Sent: 11 January 2010 02:52
To: Rebecca Morgan
Cc: Simon Chivers; Robin Uff
Subject: The former de Havilland gatehouse, Comet Way, HATFIELD- S6/2009/2554/FP

Grade II listed building.

Conservation & design advice

INTERNAL WALLS TO BE REMOVED

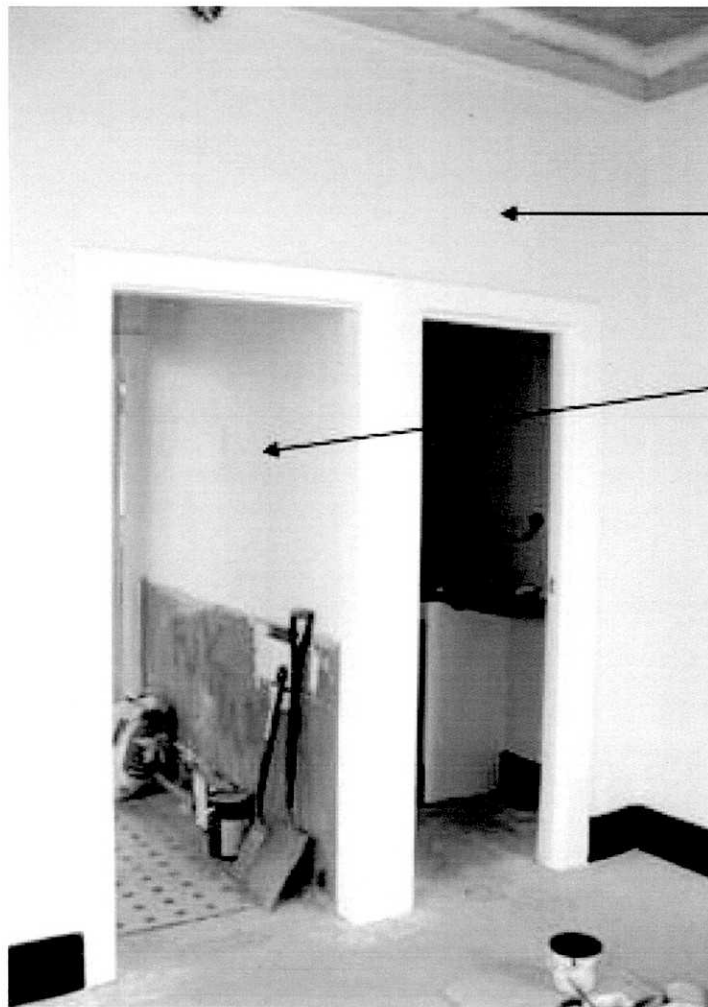
The proposed **removal of the internal partitions & associated alterations**- to effectively create an open interior space, would be damaging to the special interest of this 1930s Moderne gatehouse. Such demolition would, it is considered, significantly reduce the integrity of the surviving structure in removing the plan form of the original gatehouse. Any future use & proposed alteration of this rare building type should respect the surviving character, appearance & plan form & be prepared to sympathetically adapt to the constraints of the surviving gatehouse- rather to impose a use, involving unrealistic requirements, which would, it is felt, simply not be compatible with the preservation & enhancement of the character & appearance of the listed building. Any proposed alterations should be low-key & seek to thoughtfully retain & repair the intrinsic character & thus preserve the spirit of the building.

As noted before- the surviving floor & wall tiling in the small entrance area are also of interest & to be conserved.

Recommend: Refusal- The proposed demolition & alteration would be unacceptable in the resulting impact on the special interest, character & appearance of the Grade II listed building- by reason of the damaging effect of the removal of internal walls & associated alterations, which would be detrimental to the special interest of the original plan & integrity of the listed building.
